PLAN-022968

Proposal: Studio in rear garden.

Site: 2 Mill Cottages, Yapton Road, Barnham, PO22 0BG.

BN/17/18/HH

Title				
Drainage Layout				
Scale	As shown	At original	A4	© Robert Clark Associates Ltd
Drawing Number	1781/D1.1			Revision
				-

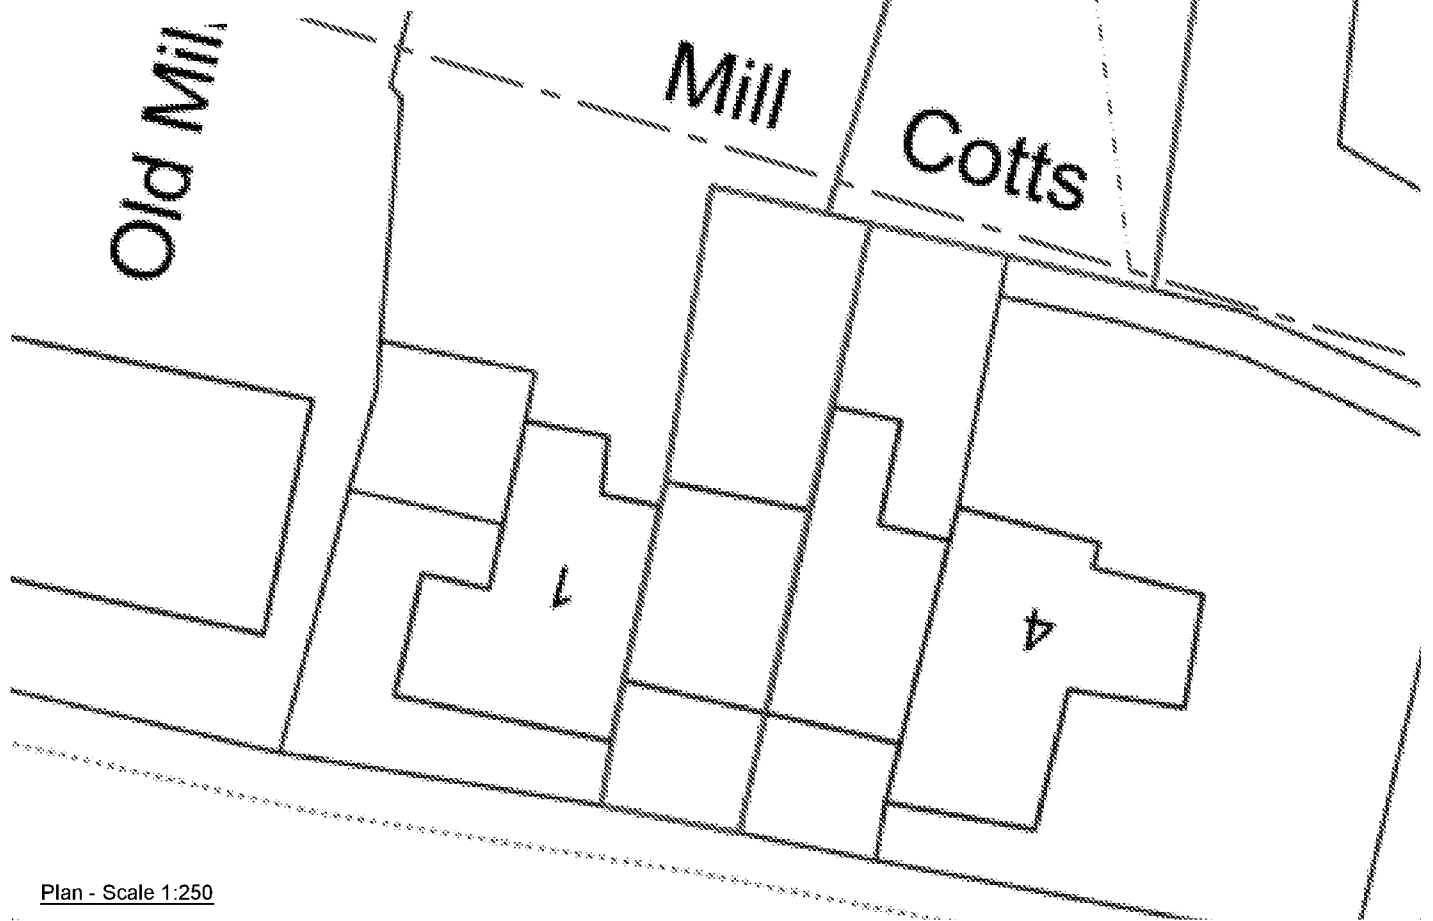
- No development or new tree planting should be located within 3 metres either side of the external edge of the foul sewer.
- No new soakaways should be located within 5m of a public sewer.
- All existing infrastructure should be protected during the course of construction works.

Southern Water requires a formal application for a connection to the foul sewer to be made by the applicant or developer.

Our initial investigations indicate that there are no public surface water sewers in the area to serve this development. Alternative means of draining surface water from this development are required. This should not involve disposal to a public foul sewer.
